Application by Fenwick Solar Farm Ltd for an Order granting development consent for Fenwick Solar Farm Project

The Examining Authority's second written questions and requests for information (ExQ2)

Issued on Wednesday 9 July 2025

Hedgerow Removal  
Sheet 2 of 5

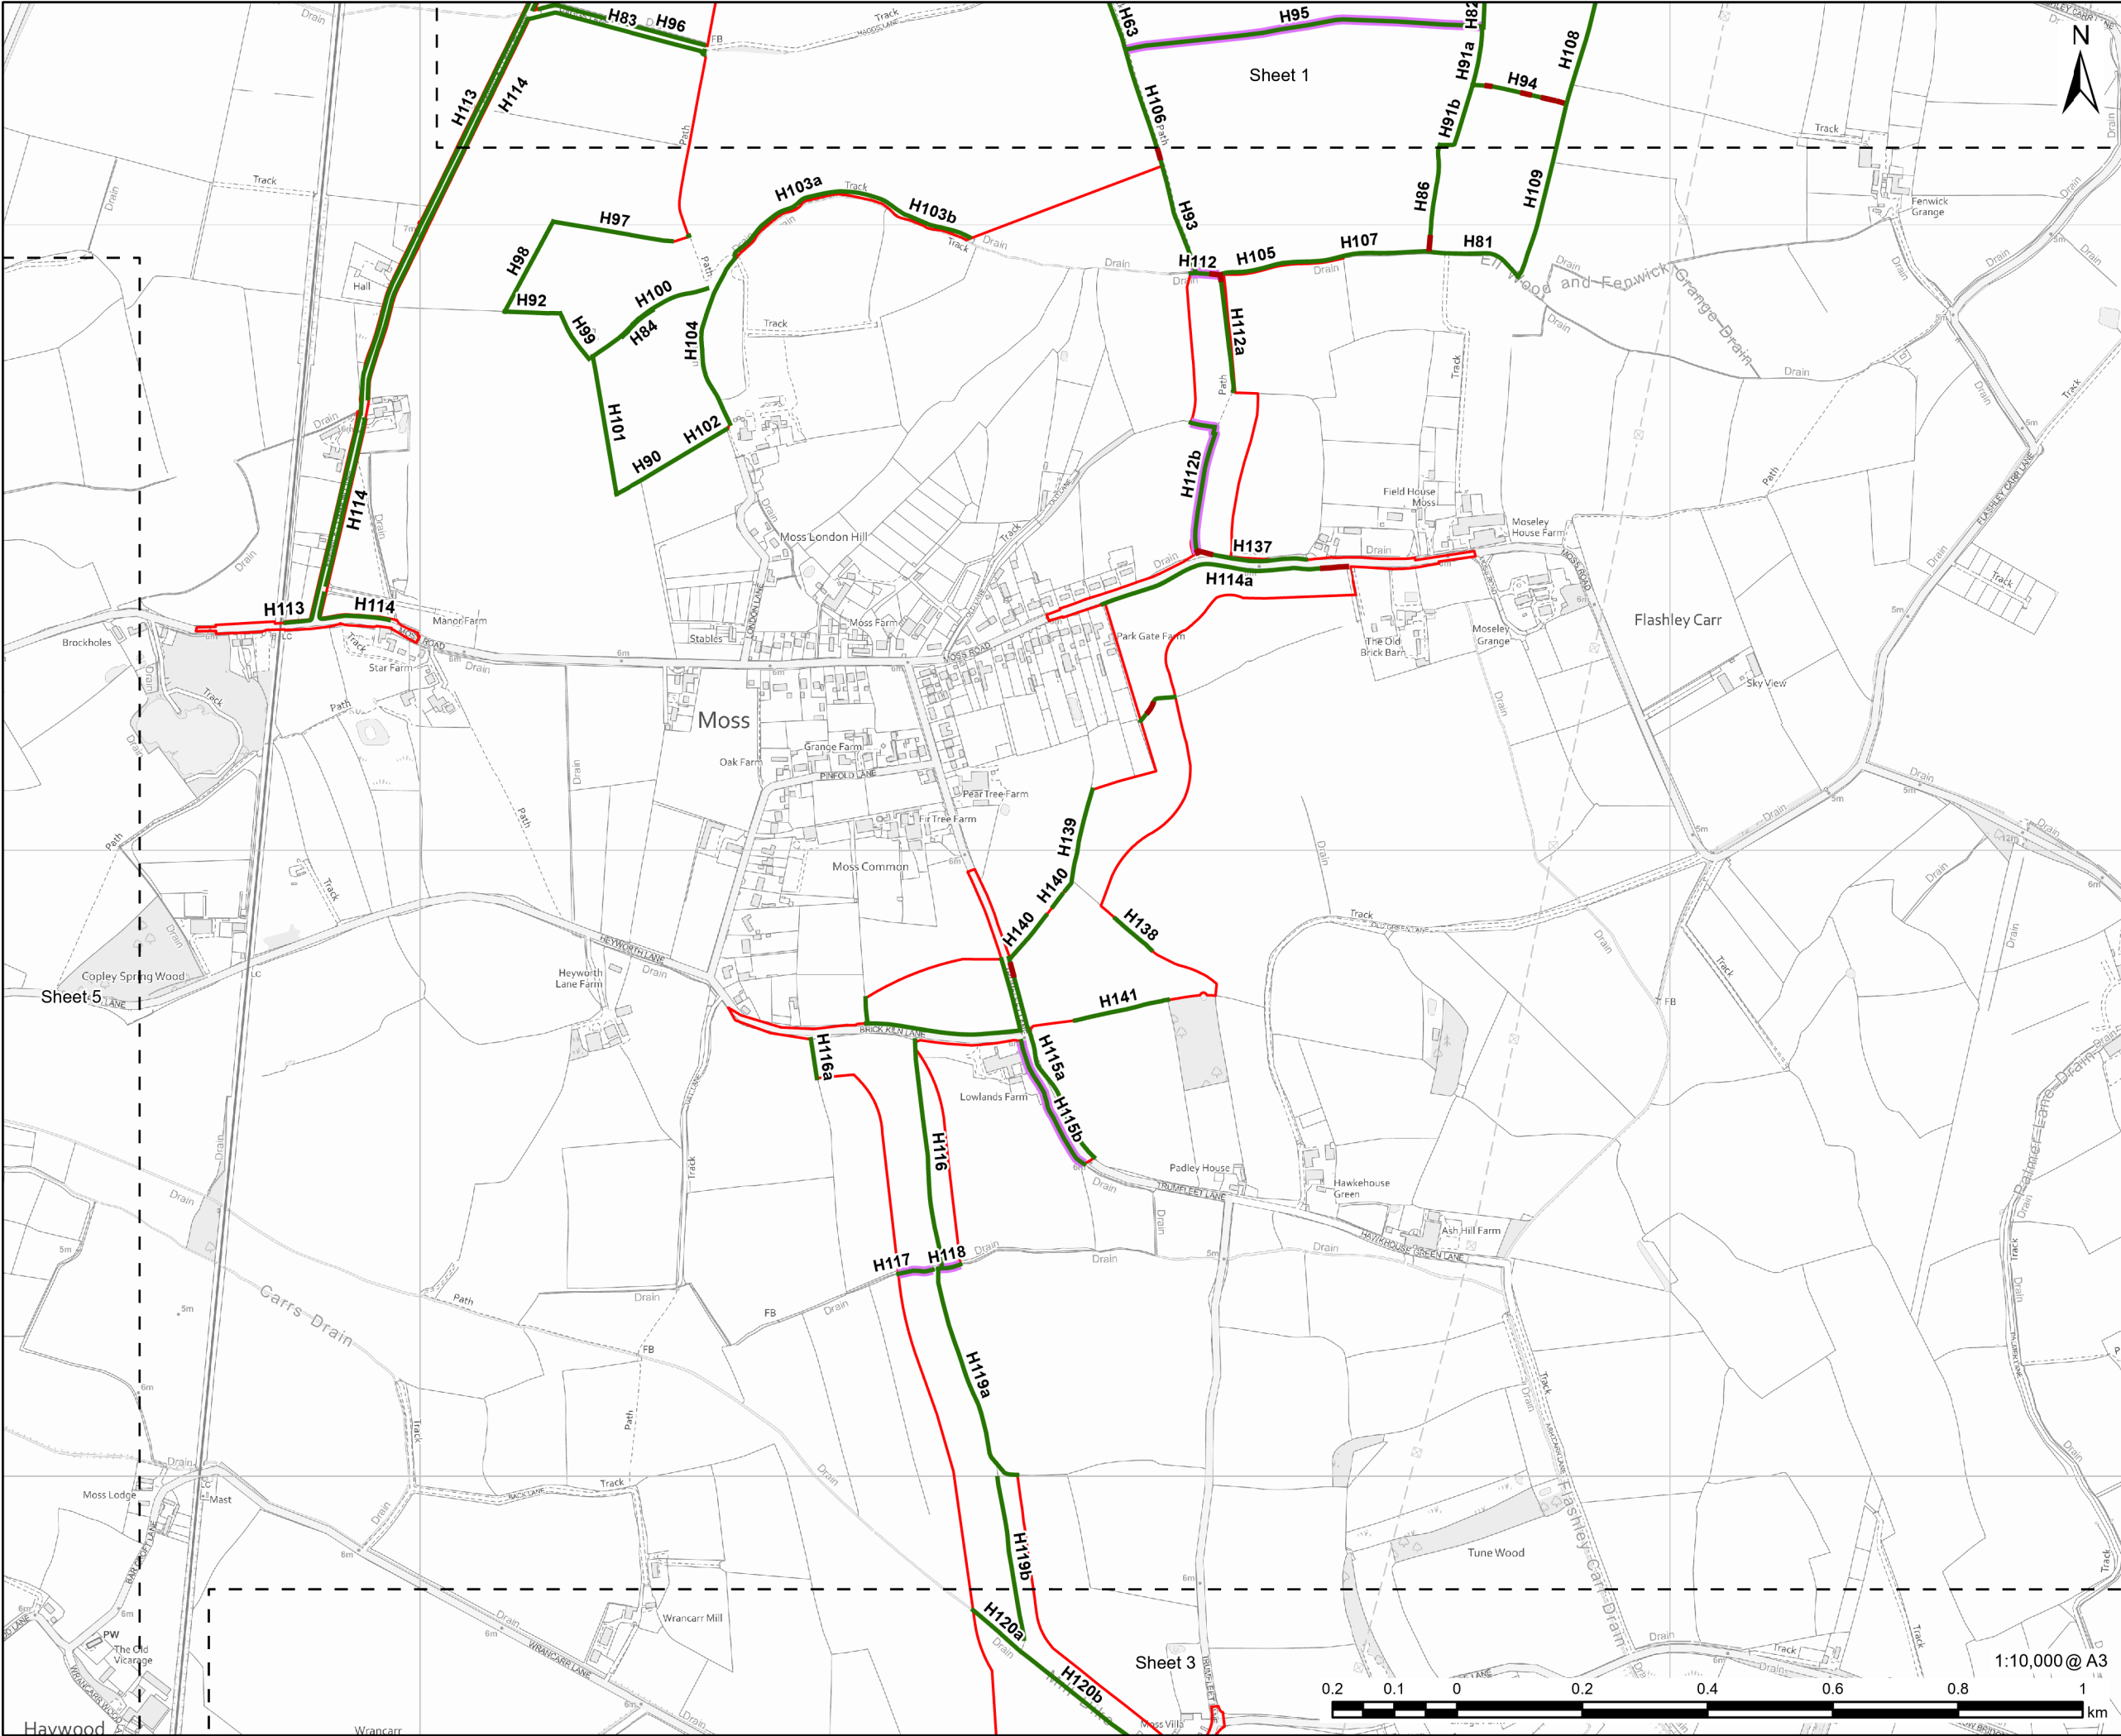
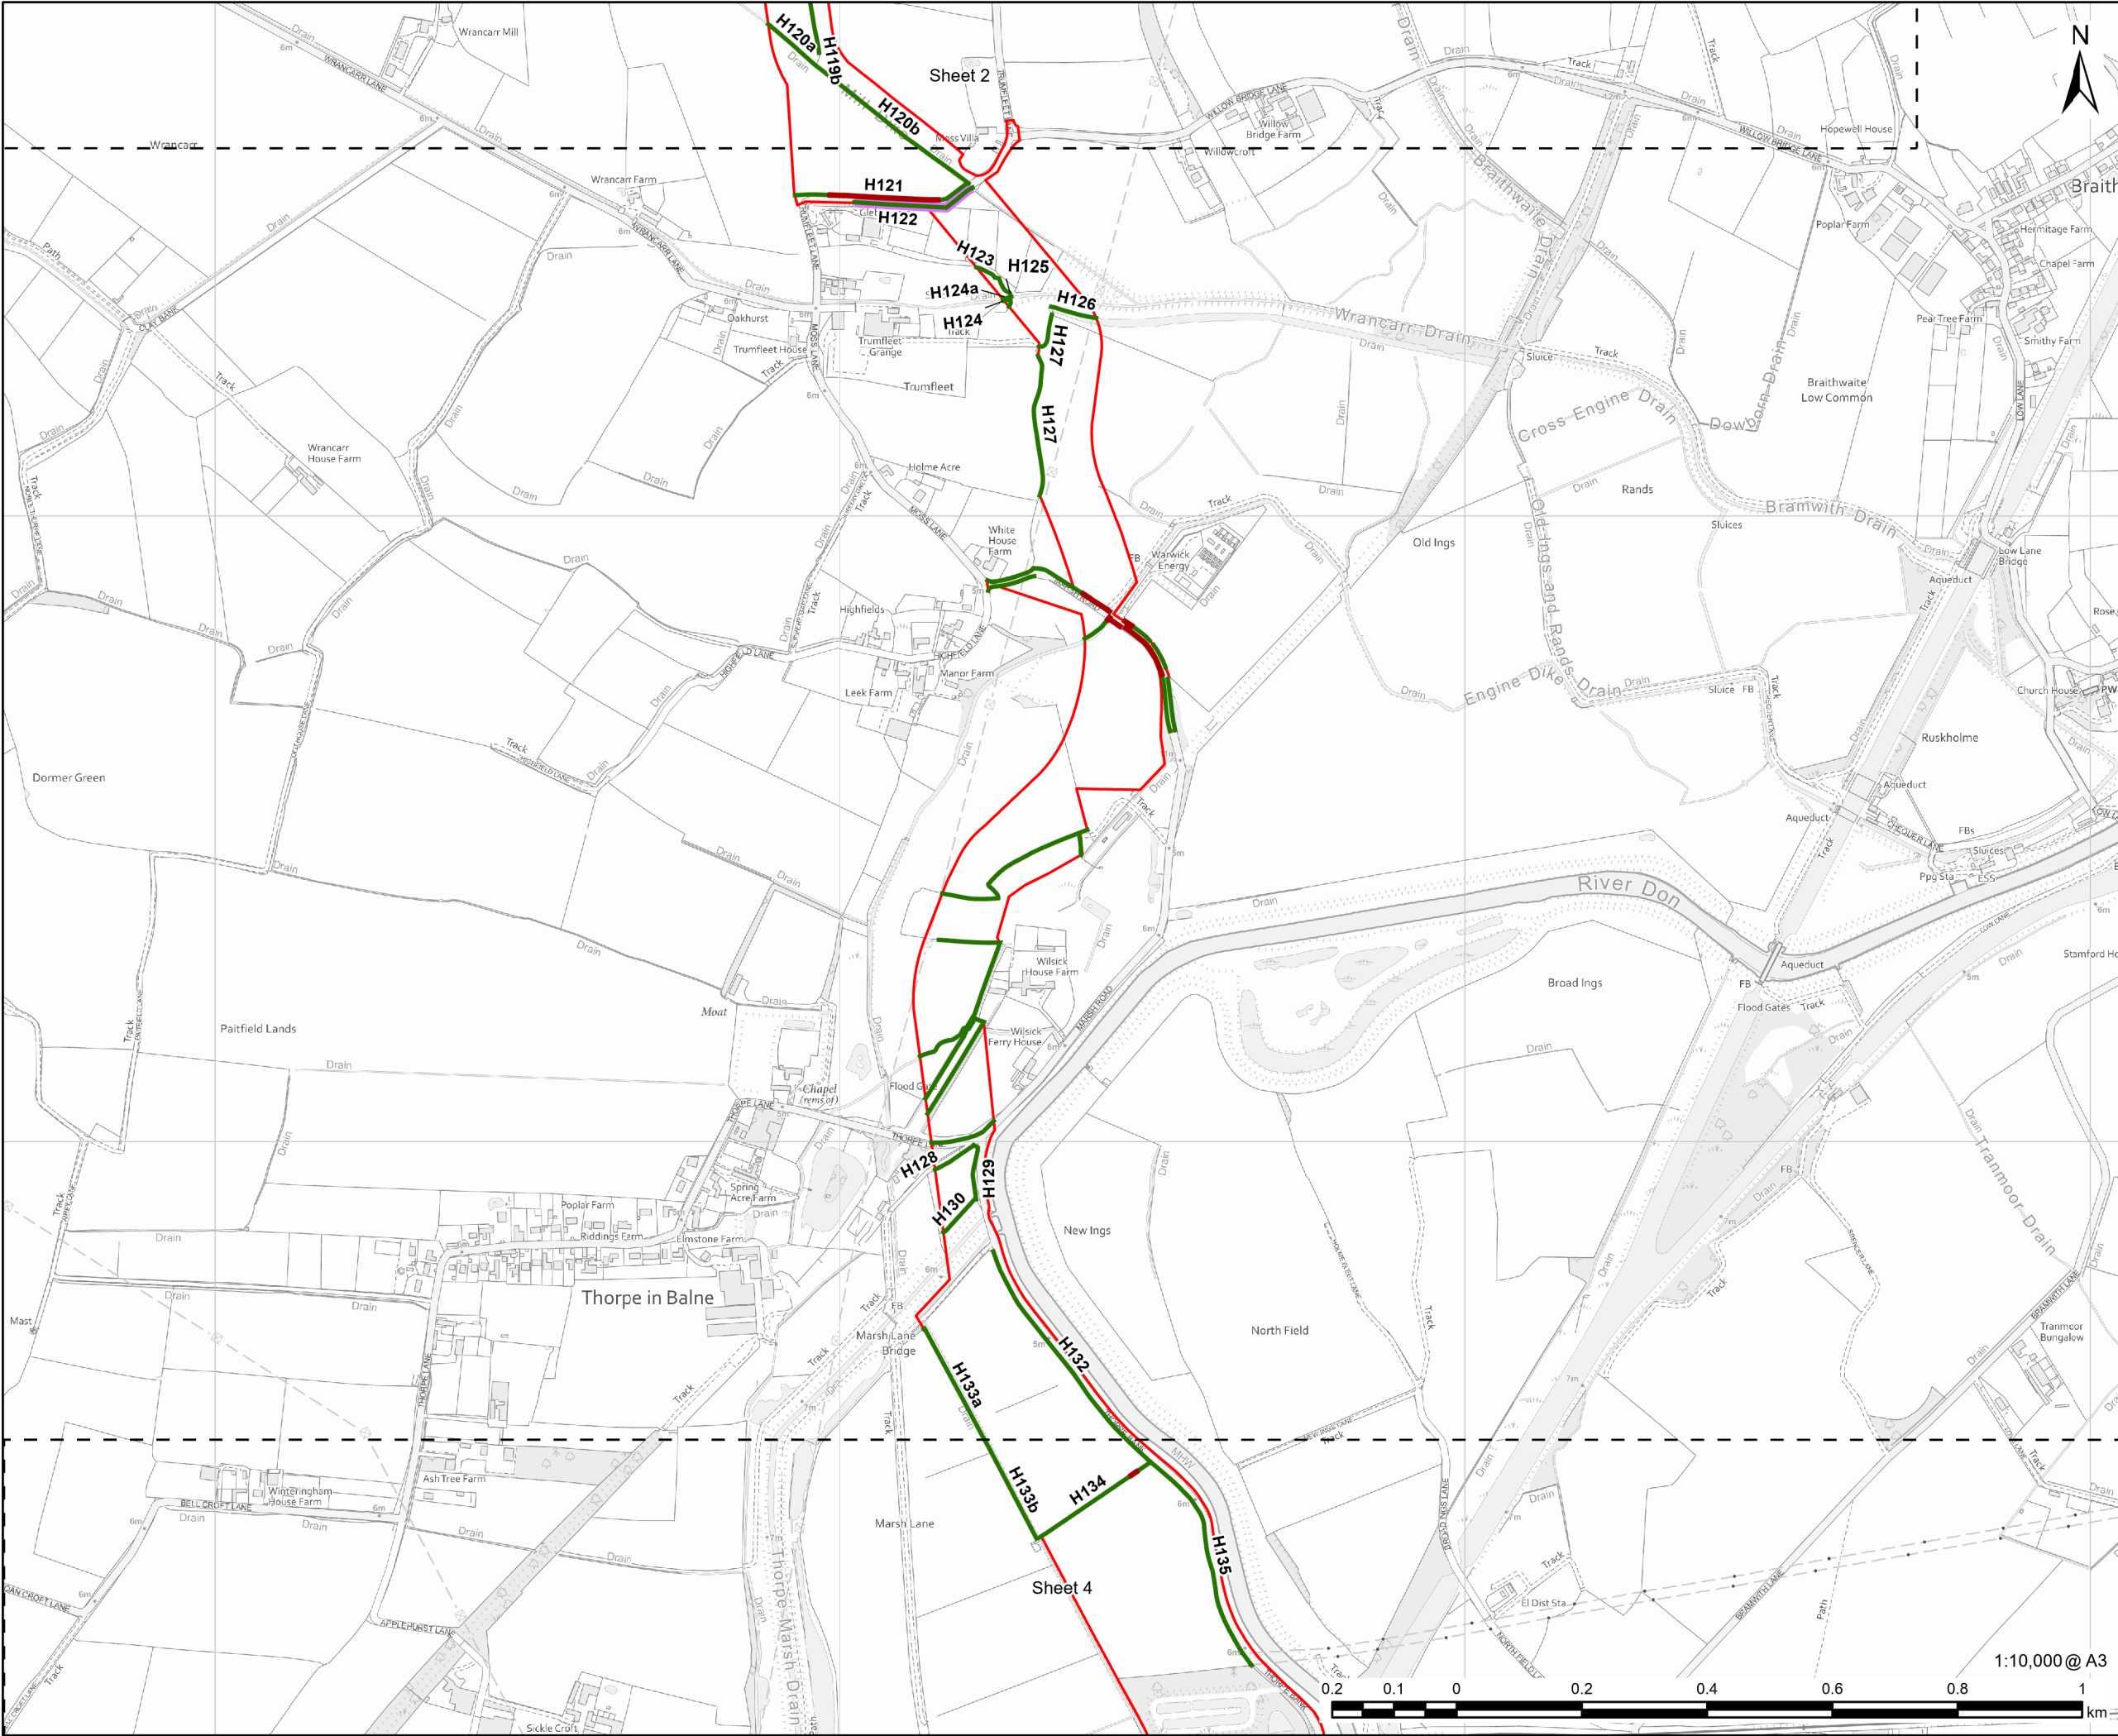
1.6.11	Applicant	Figure 8-5-2 of the Hedgerow Report [REP3-010] . Hedgerow 94 appears to have multiple sections removed as shown on figure 8-5-2 totalling approximately 77.5m in length which is approximately 53% of that total hedgerow. There is also proposed to be gapping up of this hedgerow. Please explain whether the hedgerow removal for H94 is temporary for the construction phase or the duration of the operation and in which case, how will gapping up align with this. Why is this called "N/A defunct" in table 2 under the heading "Important hedgerow Y/N".
